KIRKLEES METROPOLITAN COUNCIL INVESTMENT & REGENERATION SERVICE

DELEGATED DECISION TO DETERMINE APPLICATIONS FOR LISTED BUILDING CONSENT

Reference No:	2024/44/91707/W
Site Address:	21-23, 25 and 27 Round Ings Road, Outlane, Huddersfield, HD3 3FQ
Description:	Discharge of details reserved by condition 4 (external masonry), 8 (bi-fold doors) on permission 2024/90116 for Listed Building Consent alterations and renovations to existing dwellings 21/23, 25 and 27; erection of single storey extensions to existing dwellings 25 and 27; partial dismantling and re-building of detached barn; conversion and extension of detached and attached barns to form one dwelling; widening/improvements to existing access road, formation of parking and turning areas, together with hard and soft landscaping
Recommending Officer:	Katie Chew

Proposal Description: Discharge of details reserved by Condition 4. (external masonry) & 8. (bi-fold doors) of permission no. 2024/90116 for Listed Building Consent alterations and renovations to existing dwellings 21/23, 25 and 27; erection of single storey extensions to existing dwellings 25 and 27; partial dismantling and re-building of detached barn; conversion and

side elevation - north east

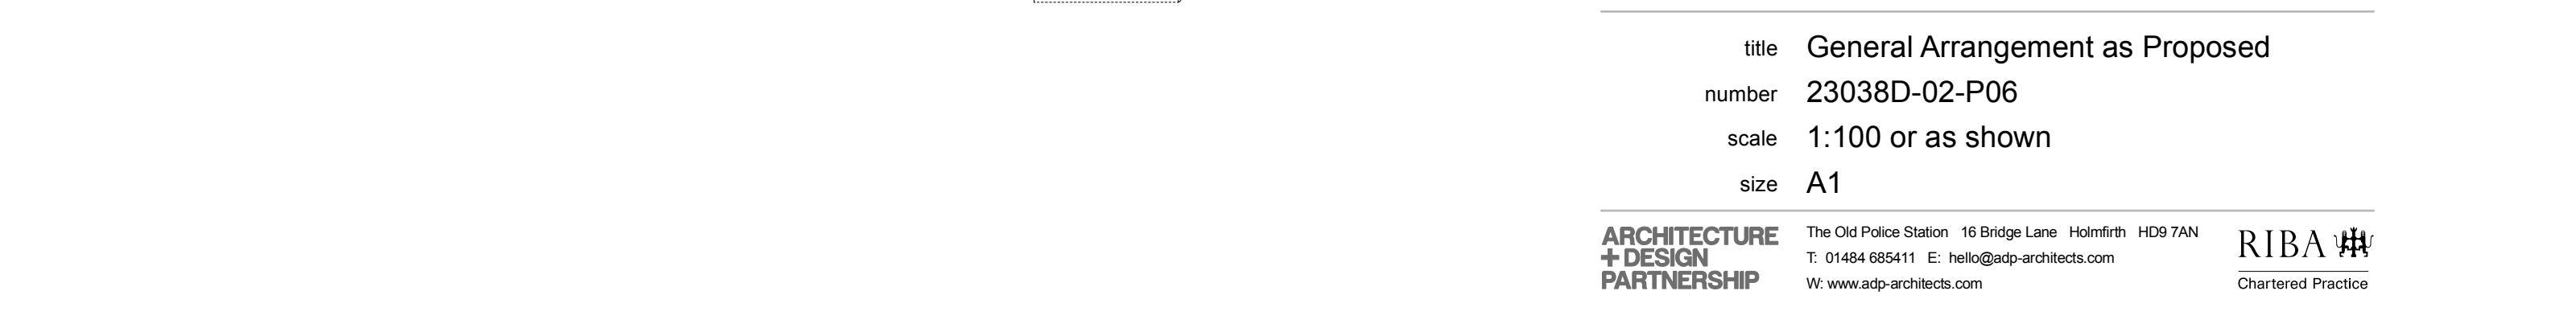
The applicant has submitted sample panel photographs submitted on the 17th June 2024 and drawing no. 23038D-02-P06 'General Arrangement as Proposed', received 17th June 2024.

Conservation & Design Officers were consulted on the proposals and noted that the sample panel shows a fine aggregate and trowelled finish rather than tamped as required, and a mixing method has been submitted rather than the mix and specification. A mortar mix and sand/aggregate specification is required, along with a revised sample panel showing a coarser aggregate and tamped finish, to enable this condition to be discharged.

Following receipt of the above comments, the applicant's agent sought to submit sample panel photographs submitted on 8th August 2024, revised drawing no. 23038D-02-P06 'General Arrangement as Proposed' which includes the mix and specification, and a Lime Mortar Mix Specification sheet.

These documents outline that all pointing will be recessed within the confines of the joint using a lime-sand mortar. Weatherstruck, strap or ribbon pointing will not be used. The mortar will be a recommended conservation mix of 1-part ionic white lime NHL 3.5 : 1.5 parts Leighton Buzzard sand: 1.5 part Nosterfield sand.

The Council's Conservation & Design team note that the amended details are deemed to be acceptable to discharge this condition. Officers concur with this conclusion and therefore Condition 4 can be discharged. It is noted however, that this condition must remain in perpetuity until the works are carried out in accordance with the approved mortar mix and sample panel, and once completed shall be retained thereafter.

title Bifold Door Details
number 23038D-07-P02
scale 1:20 and 1:2
size A2

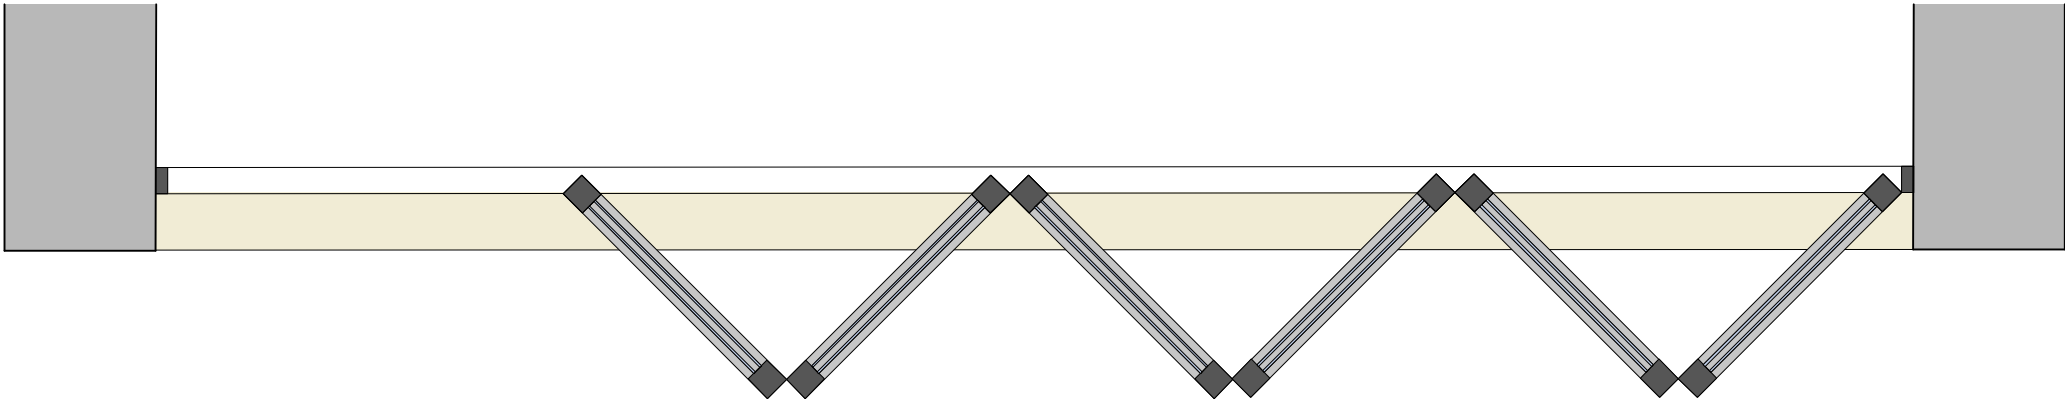
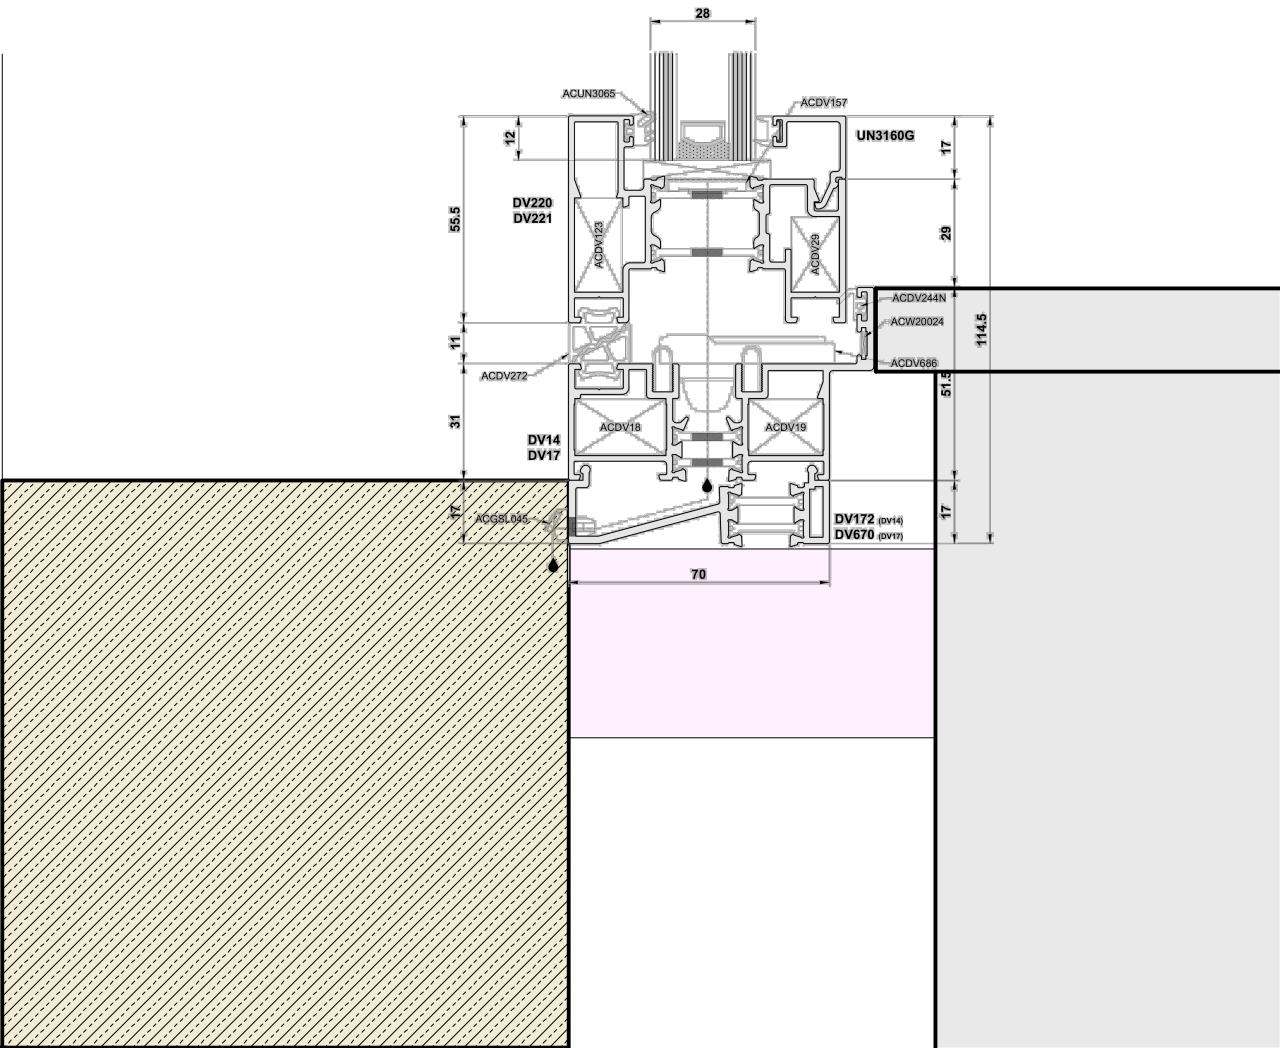
The applicant has submitted drawing no. 23038D-02-P06 'General Arrangement as Proposed', Cheshire Bi-folds Specification Details, and drawing no. 23038D-07-P02 'Bifold Door Details' in support of the discharge of Condition 8.

These documents outline that the bi-fold doors to be installed are to be Smart Visolfold 1000 Slim Bifold doors which are to be custom made from aluminium,

in anthracite grey RAL 7016. They will have a maximum insulation value down to 1.4 U W/m²K, with maximum weather proofing -BS6375 Part 1:2009.

Given the nature of this condition the Council's Conservation & Design team were consulted. They note that the drawing and specification of aluminium bi-fold doors is acceptable to discharge this condition. Officers concur with this conclusion and therefore Condition 8 can be discharged. It is noted however, that this condition must remain in perpetuity until the bi-fold doors are installed in complete accordance with the details so approved, and once installed shall be retained thereafter.
